Reference No:	<b>2026/62/90006/E</b>
Site Address:	60, Sugar Lane, Dewsbury, WF12 7AL
Description:	Erection of two storey side extension and single storey rear extension including loft conversion with rear dormer, dropped kerb and associated alterations
Recommending Officer:	Jennifer Booth

**DECISION – CONDITIONAL FULL PERMISSION**

## **OFFICER REPORT**

Proposed Elevations

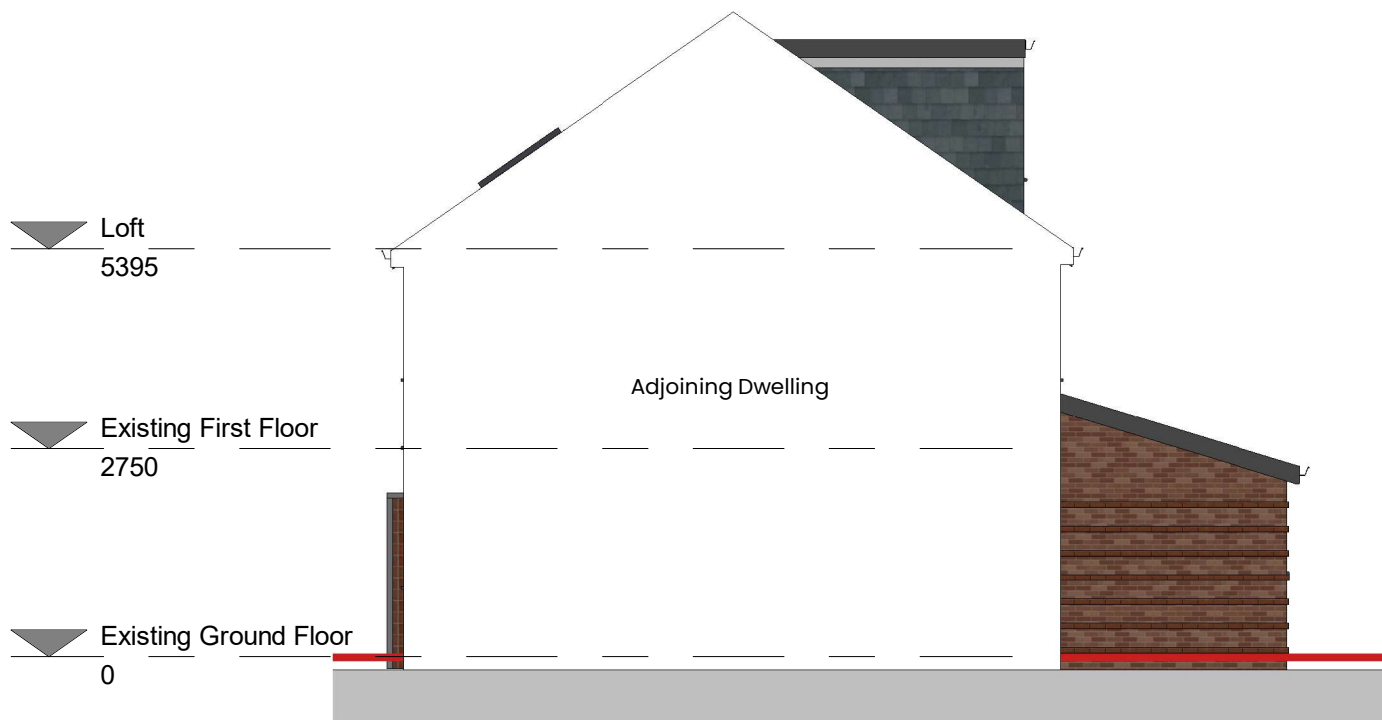
The single storey rear extension would be constructed up to the shared boundary with the adjoining dwelling. However, it is a single storey structure with a modest projection which would not result in any significant overshadowing or overbearing. The windows on the rear elevation would face into the applicants own garden.

The dormer would be set up within the roof plane. Whilst it does include a window, this would look into the applicants own garden and would offer no additional opportunities for overlooking than the existing first floor windows.

drawing
Proposed Floor Plans

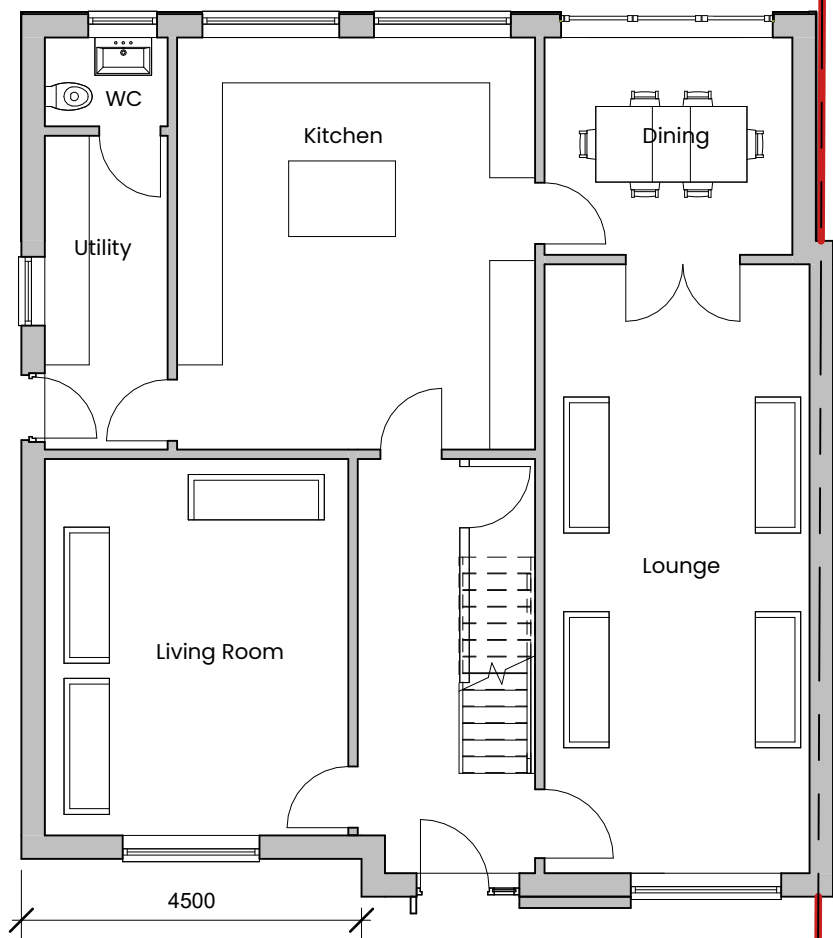
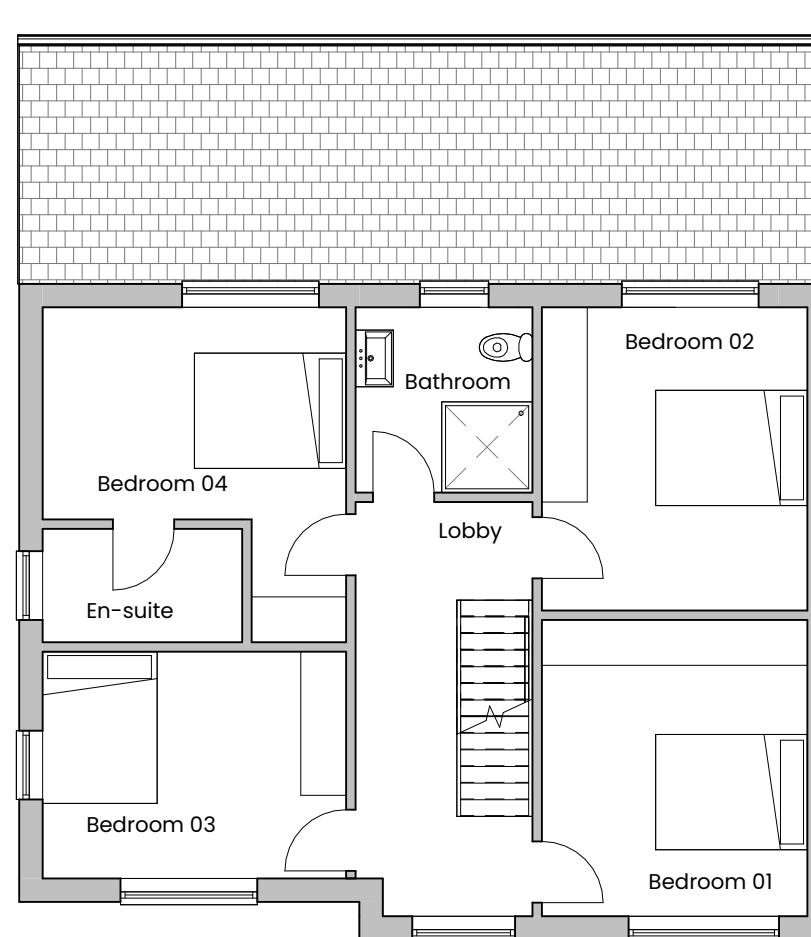
The side extension would be set back 0.5m from the front with a projection of 4.5m to the side, extending the depth of the dwelling with a pitched roof form. A 3m gap would be retained to the side of the dwelling. The roof form would be hipped.

The rear extension is proposed to project 3m from the original rear wall of the dwelling and would extend across the width of the property including to the rear of the proposed side extension with a lean to roof form.

The proposed two-storey side extension is considered acceptable in terms of visual amenity. The scheme incorporates a suitable set-back and set-down, in accordance with the Council's SPD, ensuring that the extension reads as a subordinate addition to the host property. While the overall width slightly exceeds the recommended two-thirds guideline, this is judged acceptable in this instance given the generous space to the side of the dwelling and the fact that the neighbouring buildings comprise flats of a differing form and character, reducing any risk of terracing or visual imbalance. The proposed materials would match those of the main house, and the architectural detailing is appropriate, ensuring the extension integrates well with the existing property and maintains the character of the streetscene.

The proposed single-storey rear extension is considered acceptable in terms of visual amenity. Its scale is proportionate to the size of the host property and its associated curtilage, ensuring it reads as a subordinate addition and does not overwhelm the existing dwelling. The materials proposed would match those of the main house, helping to maintain visual continuity, and the overall detailing is appropriate to the character and appearance of the property. As such, the extension is not expected to result in any adverse impact on the visual amenity of the site or wider area.

There were concerns regarding the width of the side extension and the rear dormer in terms of the formation of an incongruous feature. Amended plans were sought and received which reduced the side extension and the rear dormer. As the changes reduced the overall development, the amendments have not been advertised.

client name		
Mr Mohammed Ali		
project		
60 Sugar Lane, WF12 7AL		
drawing		
Proposed 3D Views		
project number	scale	
DAS029		
drawing number	rev	issue status
PL010	B	Planning

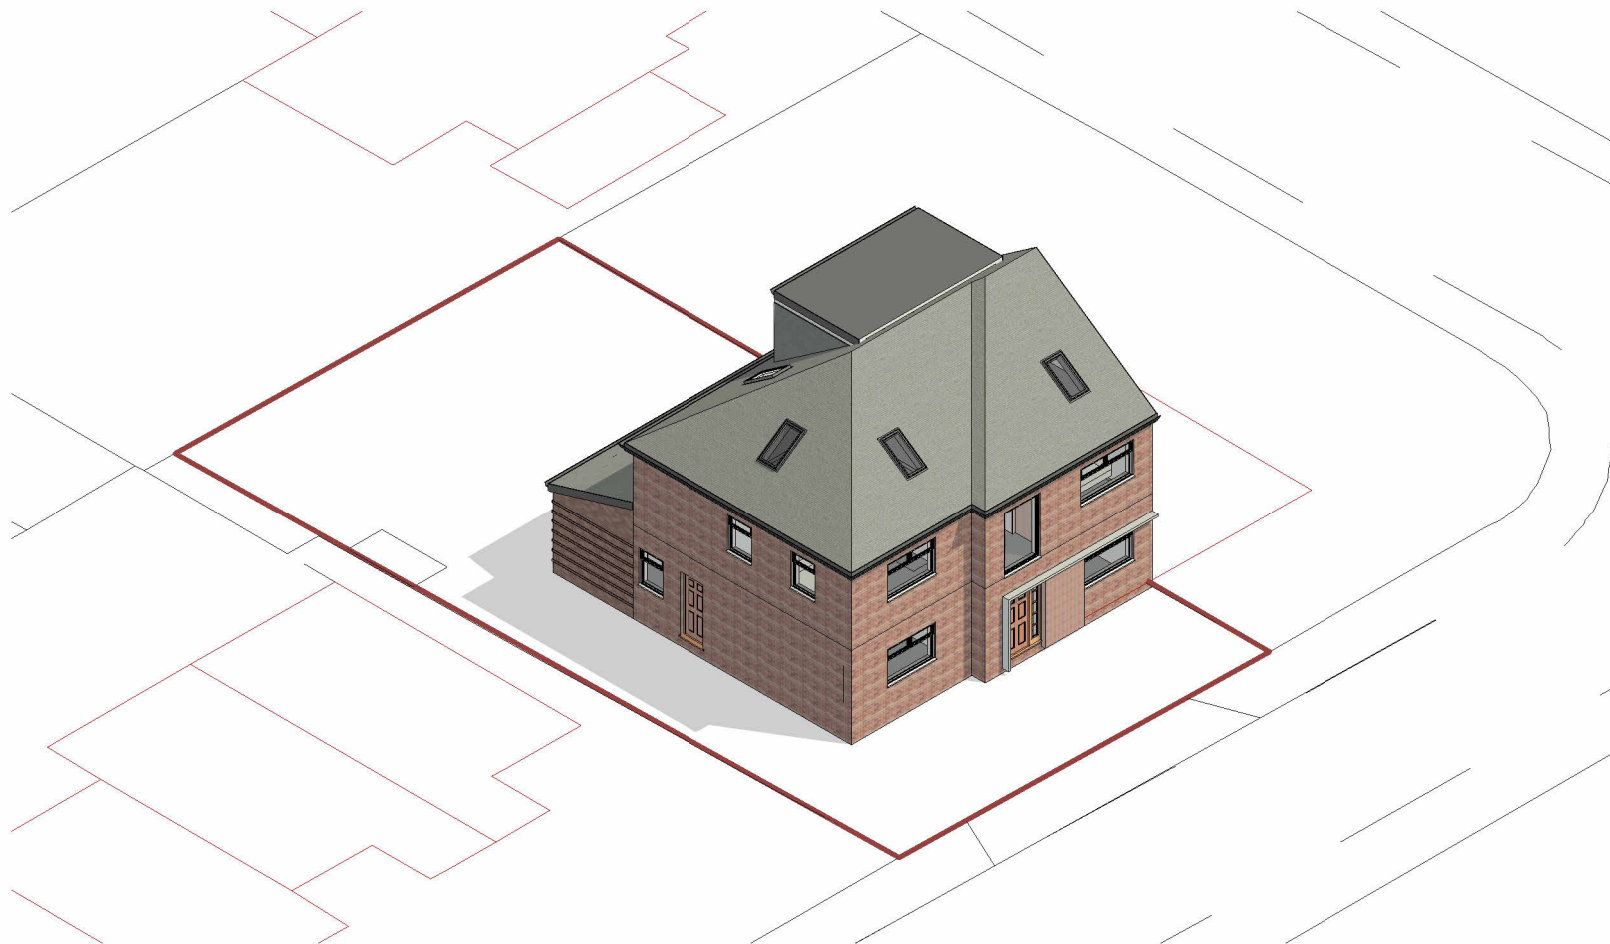
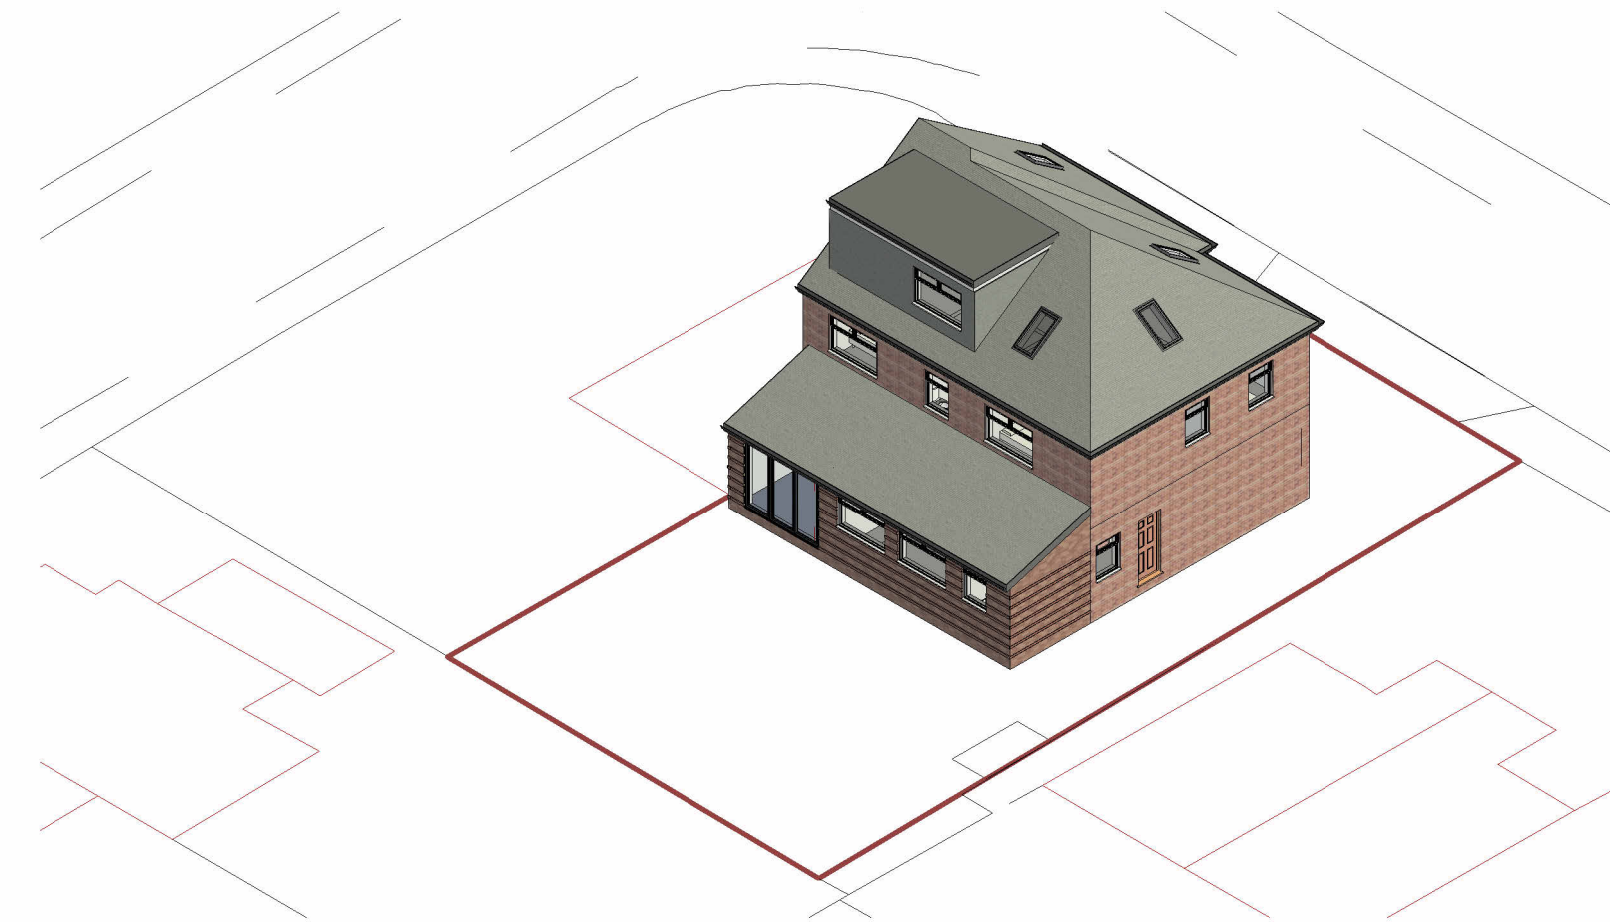
The rear dormer would have a width of 5.4m and a height of 2.3m with the face and cheeks being tile hung.

The proposed rear dormer is considered acceptable in terms of visual amenity. The dormer has been reduced from the scale shown in the initial

submission and would be set appropriately within the roof plane, ensuring it appears subordinate to the main roof form. It would be clad in grey-finished boarding, which would allow it to blend effectively with the existing roofscape. The overall design and positioning are therefore considered to respect the character of the host property and the wider area.

The property has a drive at present. The proposals are to widen the parking area to ensure an adequate parking provision whilst retaining soft hedging to the side boundaries. Whilst more planting would be preferable, the layout would not appear out of character with the area. A small amount of planting is retained.
